Reference: OR-0012083/01
Customer reference: EN110014

**EAST PYE SOLAR DEADLINE 1: ENVIRONMENT AGENCY RESPONSE – COMMENTS
ON APPLICANTS RESPONSE TO RELEVANT REPRESENTATION PART 2 [PDA-009]**

This response constitutes the Environment Agency Deadline 1 submission, made in response to [PDA-009].

CONCEPT SURFACE WATER DRAINAGE
BESS AND 400KV PROJECT SUBSTATION
BESS SITE

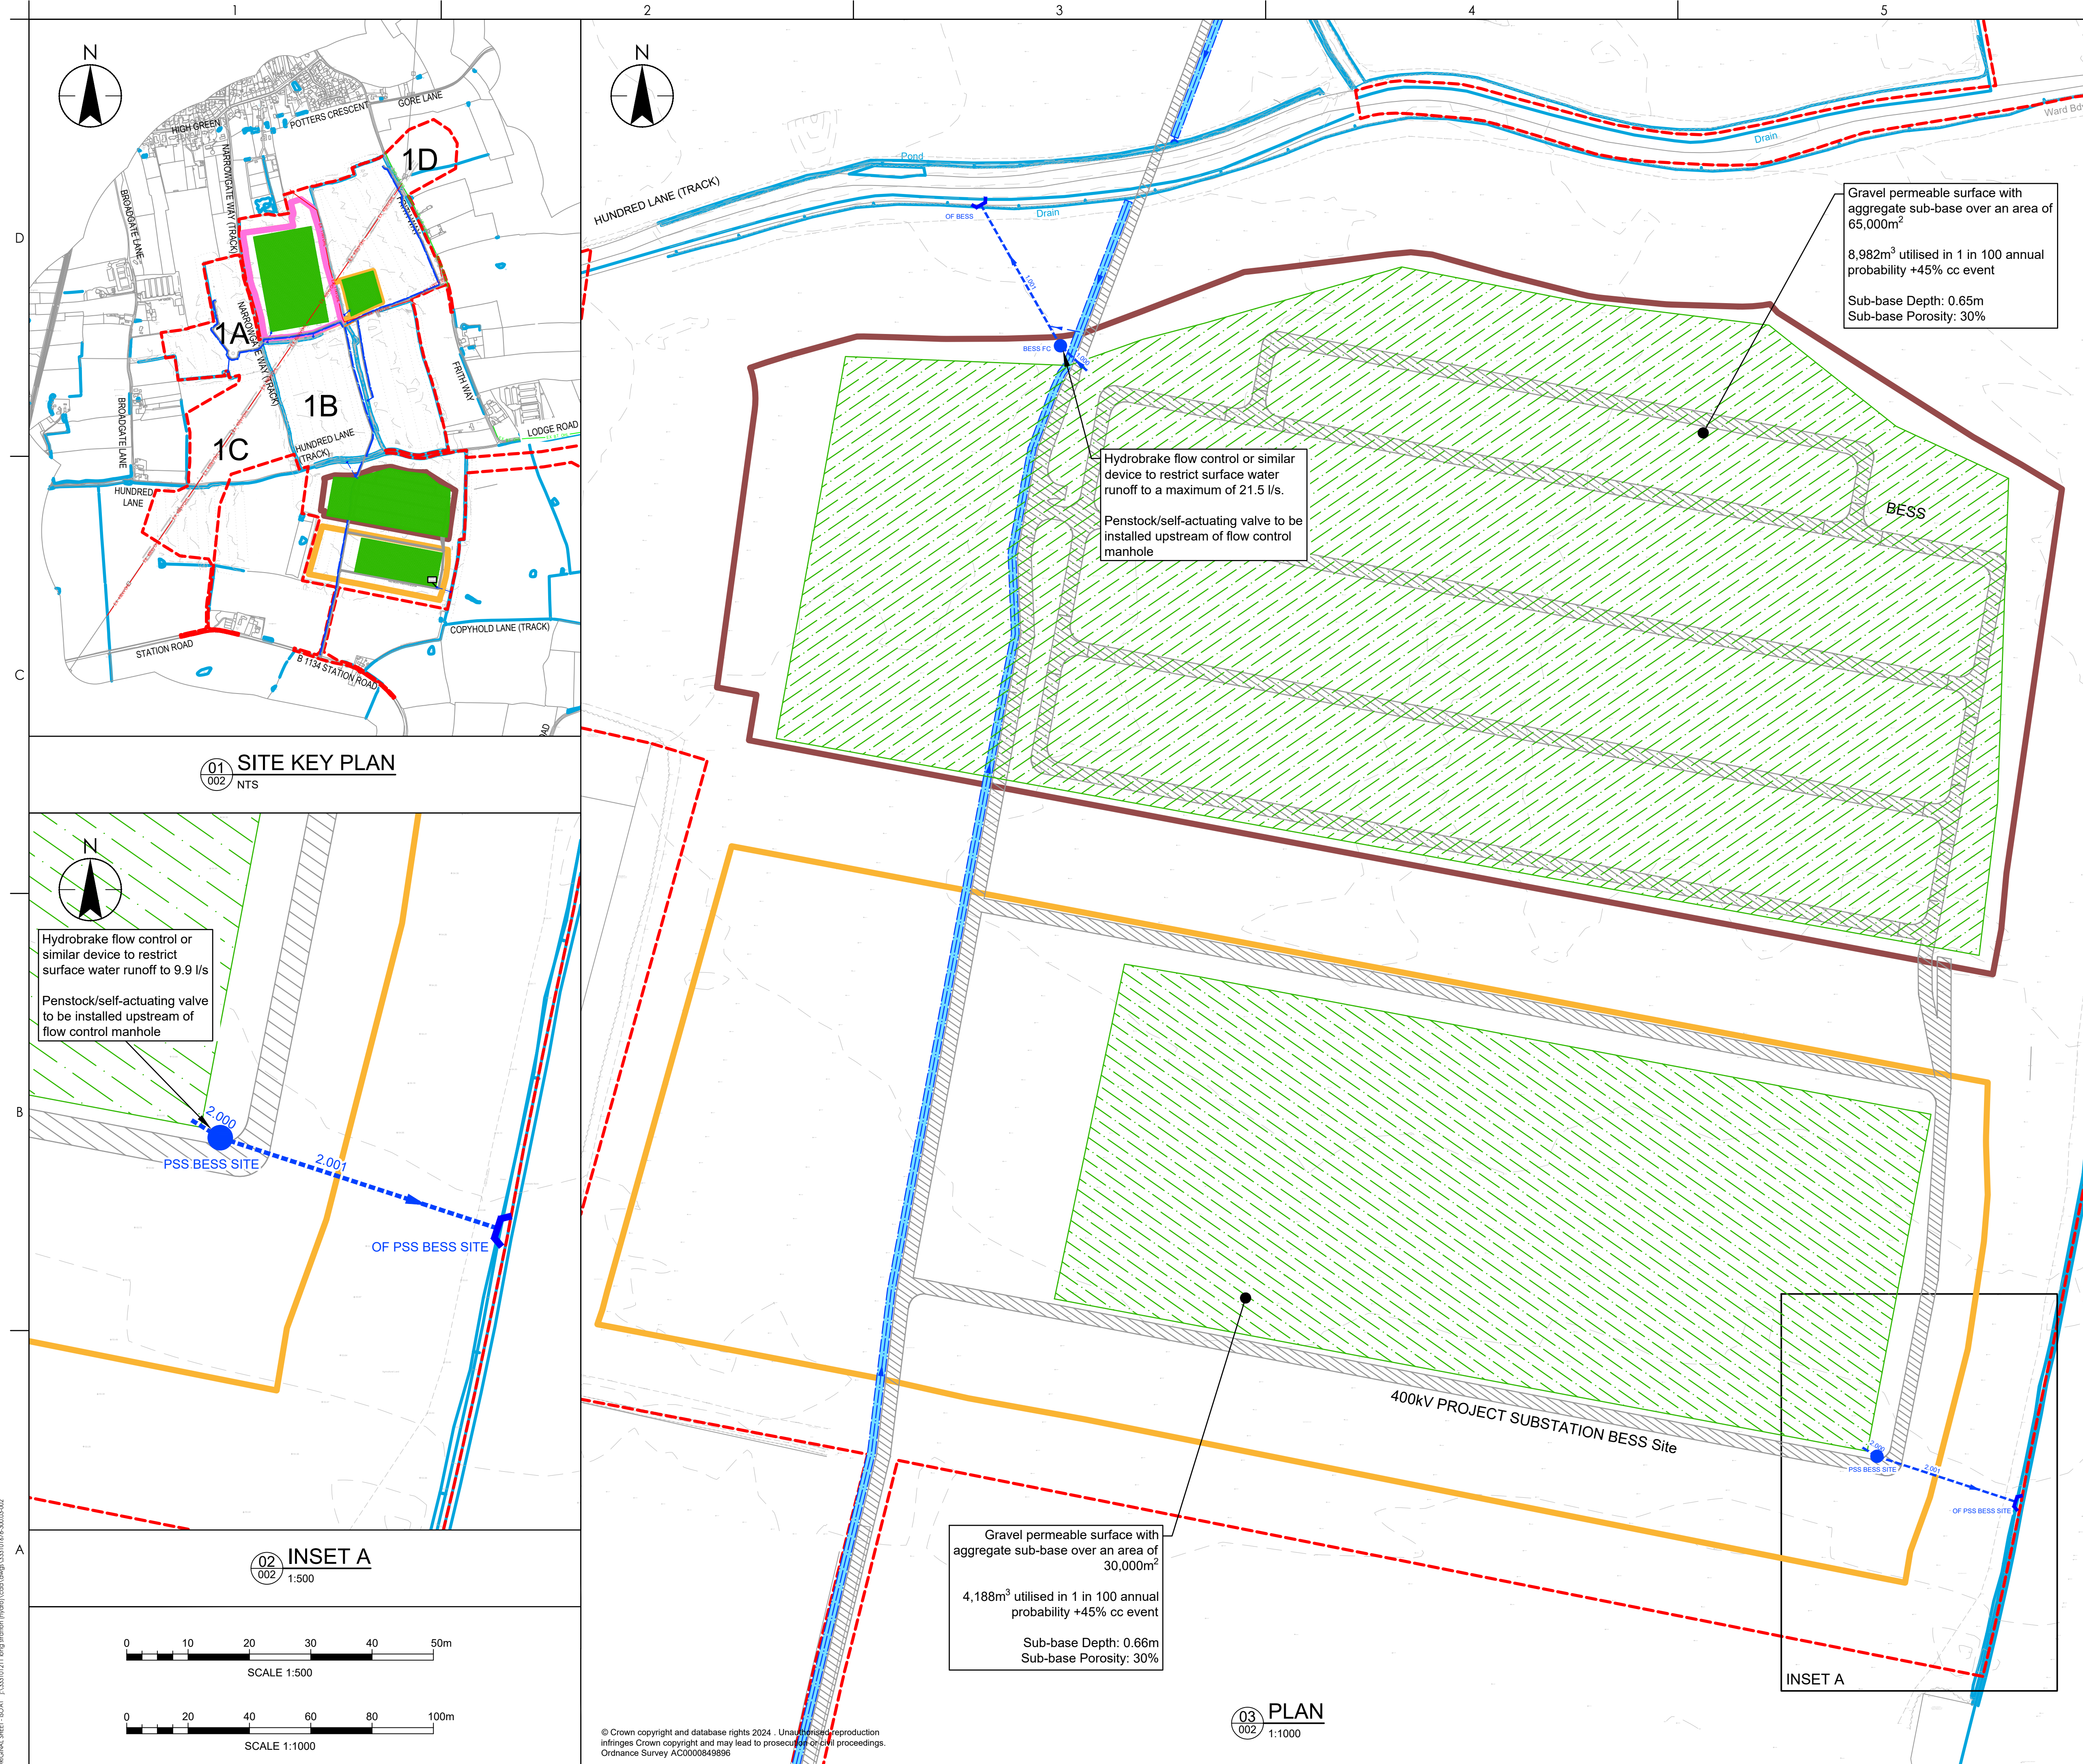
included as a named consultee in the Requirement 21 (Decommissioning and restoration) of the Draft DCO [AS-032].	
EA-020	Water Environment	Issue	Lack of clarity regarding the drainage and pollution mitigation measures for the 132kV Substations and 400kV Substations. Further details are required about penstocks and management of firewater.	The only infrastructure within the 132kV and 400kV Project Substation areas that may have a risk of fire is the transformers which will be self-bunded to prevent any leaks from reaching watercourses. If pollution is detected it will be suctioned to a self-bunded (or similar) tank and removed from site for suitable disposal. This is set out and secured within the Outline OEMP [APP 197]. The tank system for the transformer bunded area is entirely separate to the wider lined drainage system for the compounds, no surface water runoff from the transformer areas would be discharged to the water environment. As such, the surface water management strategy for the Project and National Grid Substations does not need to consider firewater management or include penstock valves for the wider compounds (given the National Grid Substation will not incorporate transformers). The proposed surface water drainage system for the National and Project	On-going. The Applicant's response is noted. We seek clarification of the controls which will be in place to manage the potential for surface water build-up within (and thus reduction in storage capacity of) the separate self-bunded drainage system for the transformers at the 400kV Project Substation.

Impact	Uncontrolled firewater drainage from substations poses a risk of pollution to the water environment.		
		Solution	Provide clarity regarding the substation drainage design and management of firewater with automated penstock valves (or similar). Ensure capacity in event of a fire to contain sufficient volumes of firewater to prevent release to environment, ensuring containment until subsequent disposal offsite.

EA-025	Water Environment	Issue	It is not always clear that the entirety of the surface water drainage infrastructure for the BESS, National Grid Substation and Project Substations would be impermeable and designed to prevent uncontrolled surface water runoff as well as subsurface infiltration.	ES Volume 3, Appendix 9.1 – Flood Risk Assessment & Outline Surface Water Drainage Strategy [AS-018] states that the BESS and Substations are designed to have a permeable surface (excluding internal access tracks) with underlying aggregate sub base. The sub-base system will be lined with an impermeable membrane to prevent the infiltration of runoff from the sub-base to the strata below. The outflow from the proposed surface water drainage system will be controlled via a flow control to an adjacent watercourse, with additional penstock valve upstream of the control for the BESS for firewater runoff control management.	Resolved. We acknowledge that the Battery Energy Storage Systems (BESS) and Substations will incorporate an impermeable lining beneath the sub-base to prevent infiltration of runoff into the underlying strata, and that surface water will be discharged via flow control to an adjacent watercourse, including a penstock valve to control firewater runoff from the BESS. We acknowledge that transformers have been assessed by the Applicant as the only infrastructure considered to pose a hazardous substance risk to controlled waters, and these will be self-bunded. The Applicant identifies that text regarding remediation of the BESS drainage system will be provided in the detailed OEMP at detailed design stage. The Environment Agency is a named consultee in the Draft DCO for approval of the drainage scheme (Requirement

Impact	Surface water drainage infrastructure at these features may result in uncontrolled discharge of potentially contaminated runoff if design is inadequate.	This is secured through the Outline BSMP [APP-200].	
		Solution	It should be clearly stated that the surface water drainage systems at these features would be impermeable and designed to prevent infiltration and uncontrolled surface water runoff. The Applicant should also identify how damage to the impermeable membrane from construction activities such as piling would be avoided. Substations should	The Outline CEMP [APP-196] and Outline OEMP [APP-197] set out that all chemicals will be stored within a secure and bunded impermeable area. The infrastructure that is considered to contain a hazardous substance is transformers which will be self-bunded to prevent any leaks from reaching watercourses. If pollution is detected it will be suctioned to a self-bunded (or
